**From:** Amanda Scholes on behalf of Planning.Responses  
**Sent:** 28 July 2017 09:14  
**To:** Planning Scanning  
**Subject:** FW: EP/88/17/DOC : Bradbury Hotel Site, East Preston

Yes this appears to be the missing percolation testing information requested in my email dated the 30<sup>th</sup> June (item 2). It is noted that the tests were probably undertaken in October 2016 (ie. the date that these forms were completed). This date is at the start of the winter period so is unlikely to satisfy our requirement for undertaking the percolation testing at an agreed time during mid-winter when ground conditions are less favourable. However, they have used the worst percolation rate (ie. that in trial pit no.2) for the soakaway designs. This would therefore seem a reasonable compromise and acceptable for use in that part of the site. Regarding item 2, I would suggest that the applicant undertakes trial holes to confirm the following;

NB. ALL SOAKAWAYS TO BE 1.0m IN DEPTH. CELLULAR SOAKAWAYS (AQUACELL OR EQUIVALENT) WRAPPED IN 300G GEOTEXTILE PERMEABLE MEMBRANE AND SURROUNDED IN 100MM COARSE SAND. MIN COVER TO SOAKAWAY IS 750mm. SOAKAWAY DESIGN BASED ON INFILTRATION RATE OF 8.74x10⁻⁵ m/s. AS CONFIRMED ON SITE TO BRE DIGEST 365.

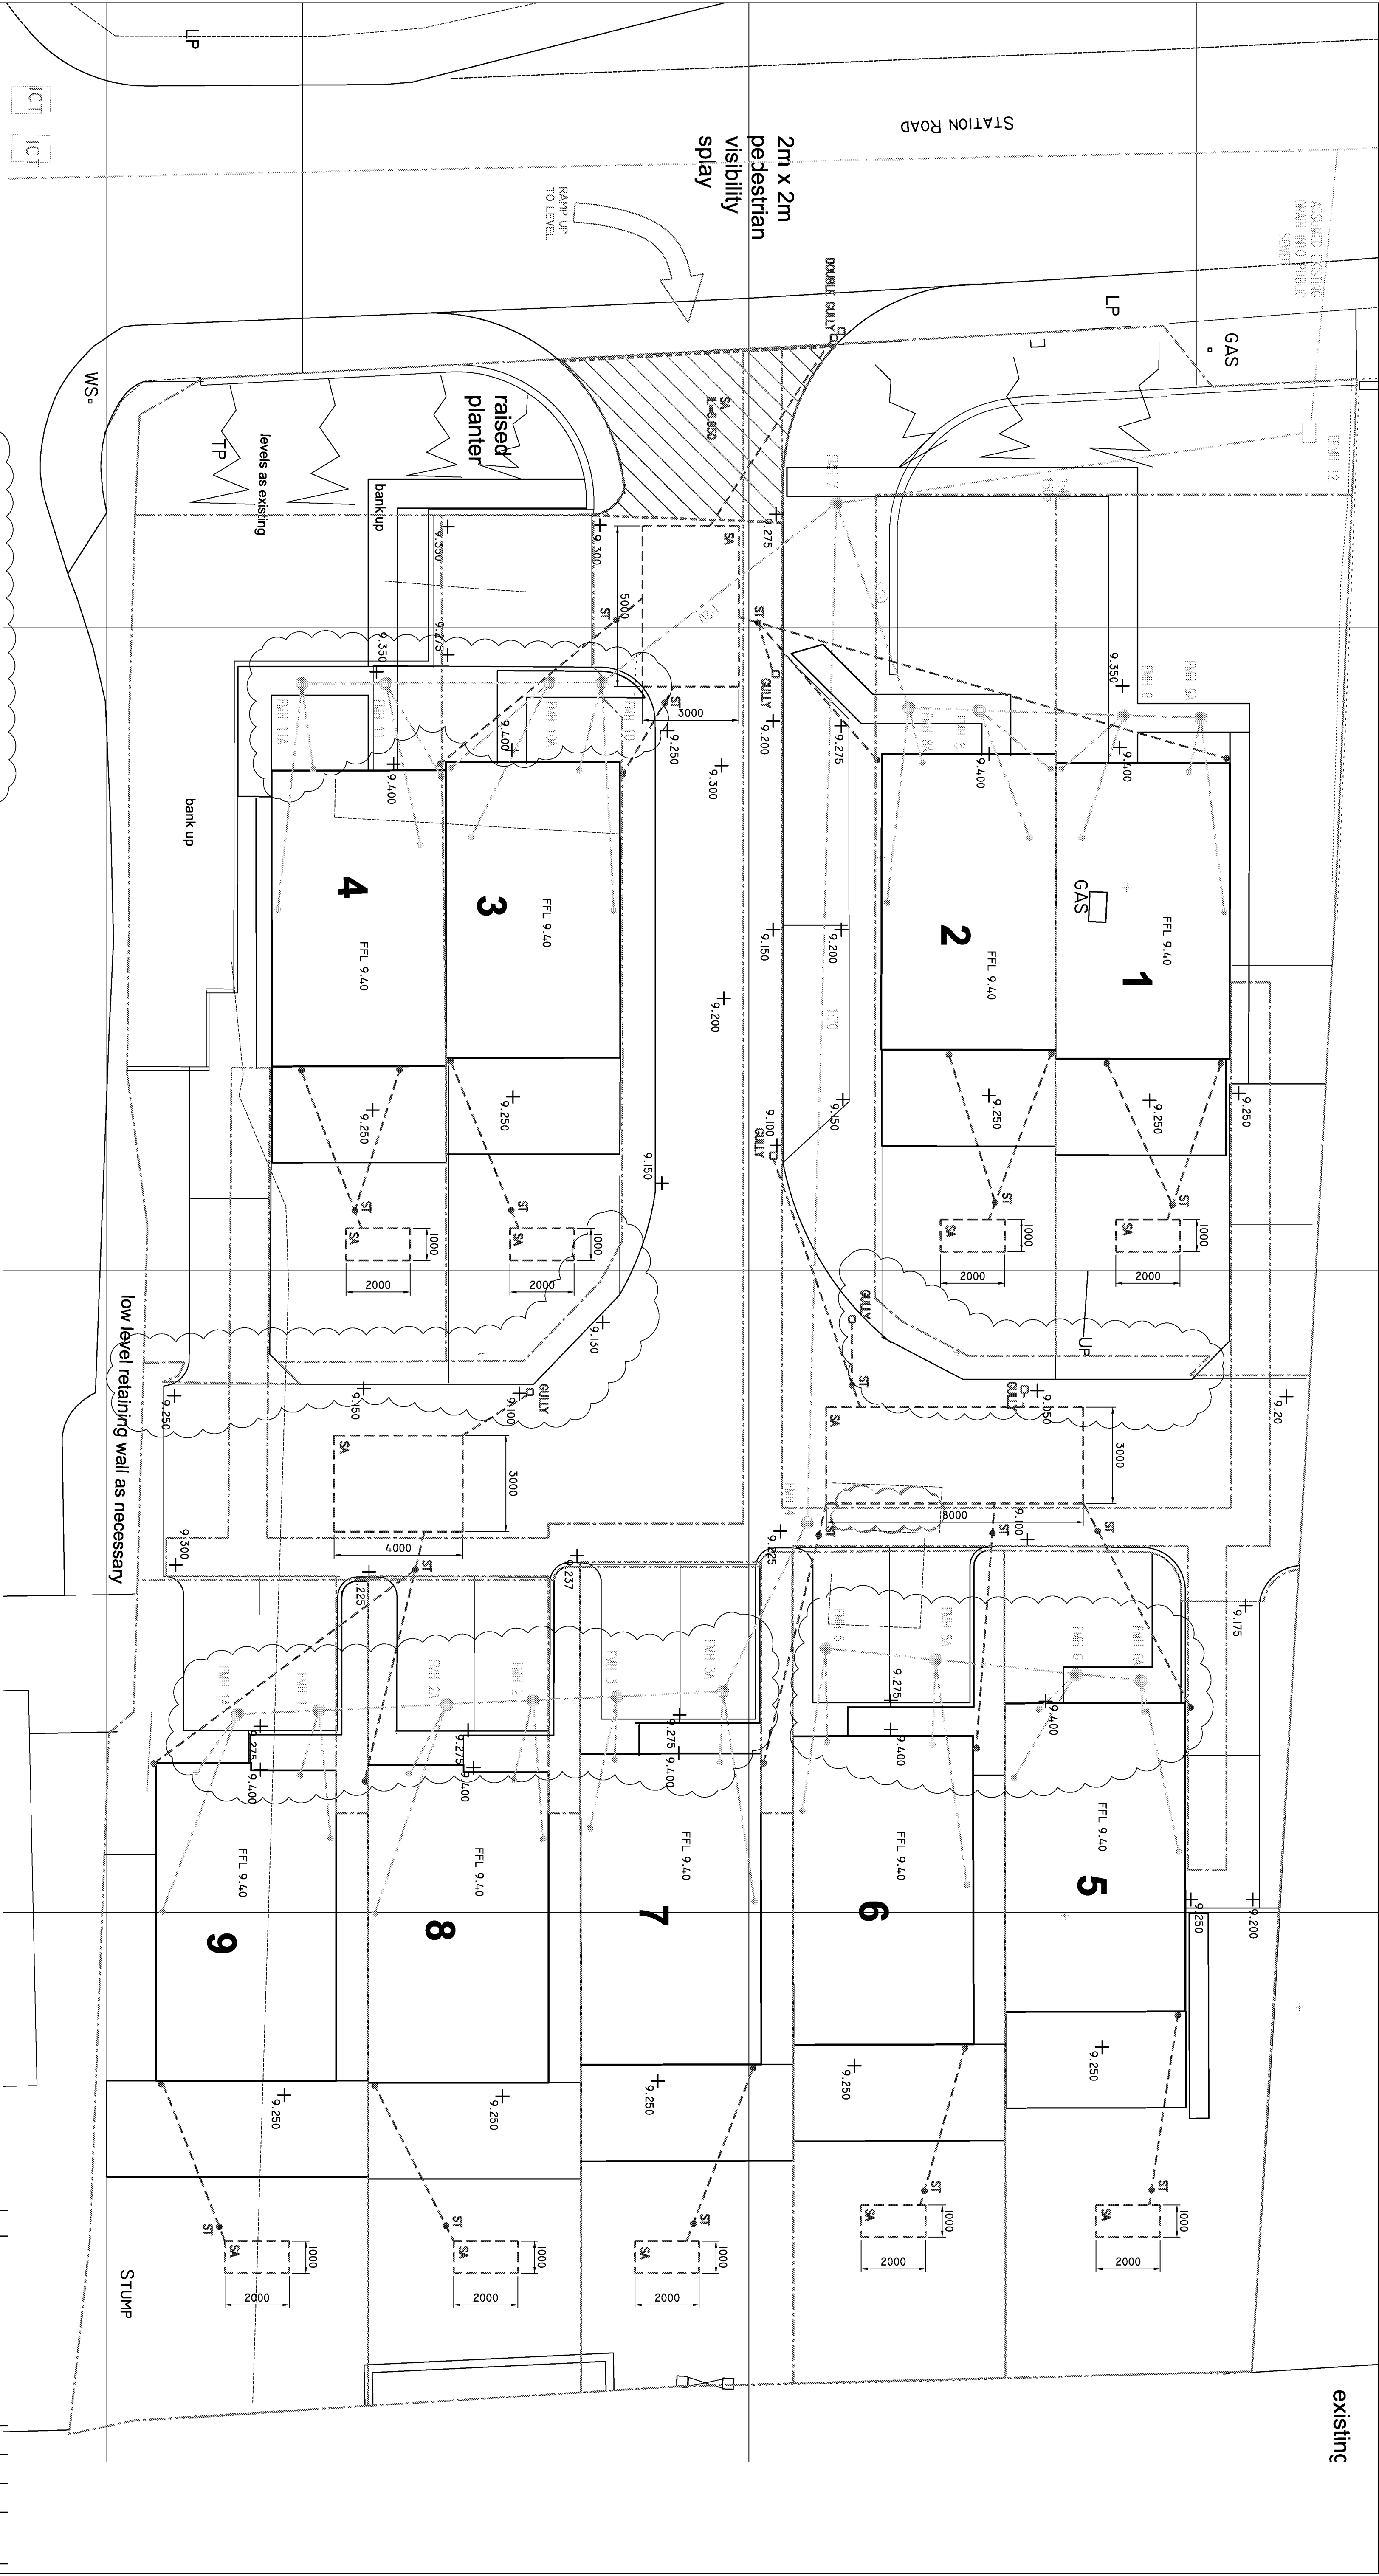
To try and move the matter forward I have re-consulted our Engineer who has advised that he is not requesting testing as such just excavating trial holes to confirm ground conditions and whether the base of the soakaways made contact with the gravel layer. Depending on the situation on site, dictates on where these are possible, without causing too much disruption.

1. Next to soakaway in rear garden of plot 9.
2. Next to soakaway in rear garden of plot 5.
3. Next to soakaway in rear garden of either plots 1 or 2.
4. Next to soakaway in rear garden of either plots 3 or 4.
5. Assuming the access road is built, it could be difficult to excavate next to one or two of the soakaways in the road. Perhaps the situation can be confirmed. If this is the case, then perhaps a trial hole in the vicinity of the entrance to the site.

1. That ground conditions in other parts of the site where percolation testing wasn't carried out are of a similar make up.
2. That the bases of all of the soakaway structures made contact with the gravel layers (at approx. 2m depth)

Since it appears unlikely that we'll hit the gravel layer in this area, and to save a lot of time and testing – could be suggest we build an 'overflow soakaway' which hits the gravel layer – We'll then over flow the existing one in to this.

If we were to build this extra provision for just the soakaway at the front of the site, where the gravel layer was identified to be deeper, would you accept the construction depth of the other soakaway's which are covered by the recent 365 tests?
